HIGHWAY REPORT ON PROPOSALS FOR DEVELOPMENT

DISTRICT:	Bassetlaw	Date received	05/07/2022
OFFICER:	Eleanor Grant		
PROPOSAL:	Demolition of an Existing Derelict Bungalow and erection of a Detached House and Garages.with new vehicular access	D.C. No.	B/22/00863/FUL
LOCATION:	Land Including Littlewood House Wheatley Road Sturton Le Steeple Retford Nottinghamshire DN22 9HU		
APPLICANT:	Mr Byron Foster

SITE PLAN

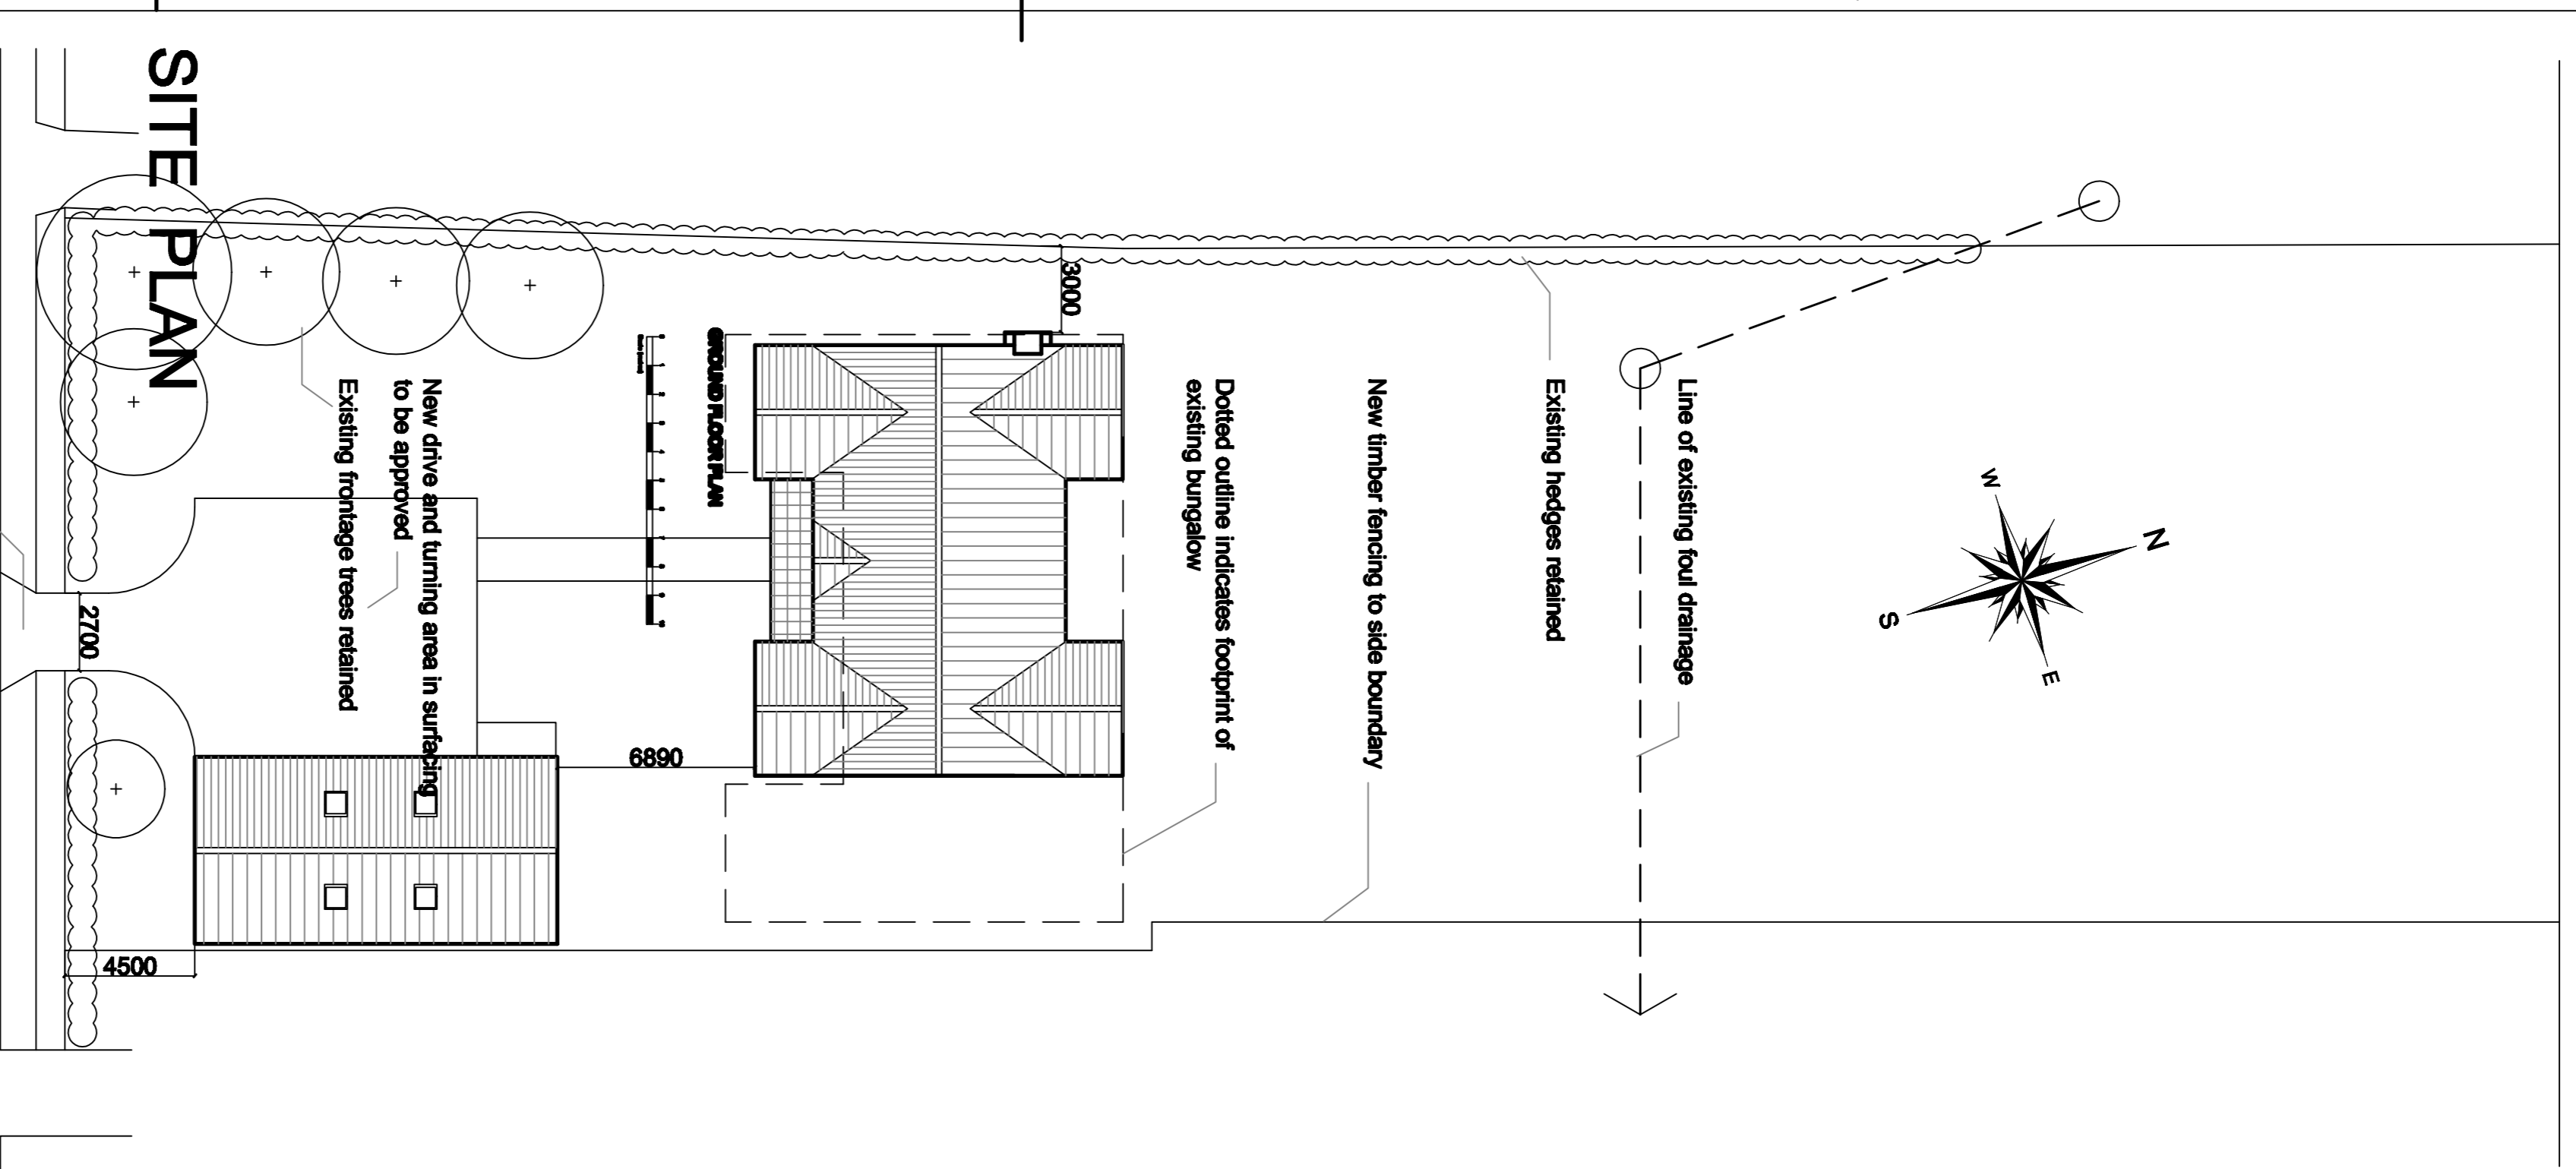
The Highway Authority has no objection to a replacement dwelling and the creation of a new access that is currently shared with the adjacent dwelling. A condition is requested to secure satisfactory access arrangements.

- Prior to the dwelling being occupied the driveway shall be surfaced in a bound material (not loose gravel) for a minimum distance of 6.0m from the highway boundary, shall be drained to prevent the unregulated discharge of surface water onto the public highway, and a dropped vehicular footway/verge crossing shall be provided as detailed on Drawing Number P22.0510.03 Rev C.
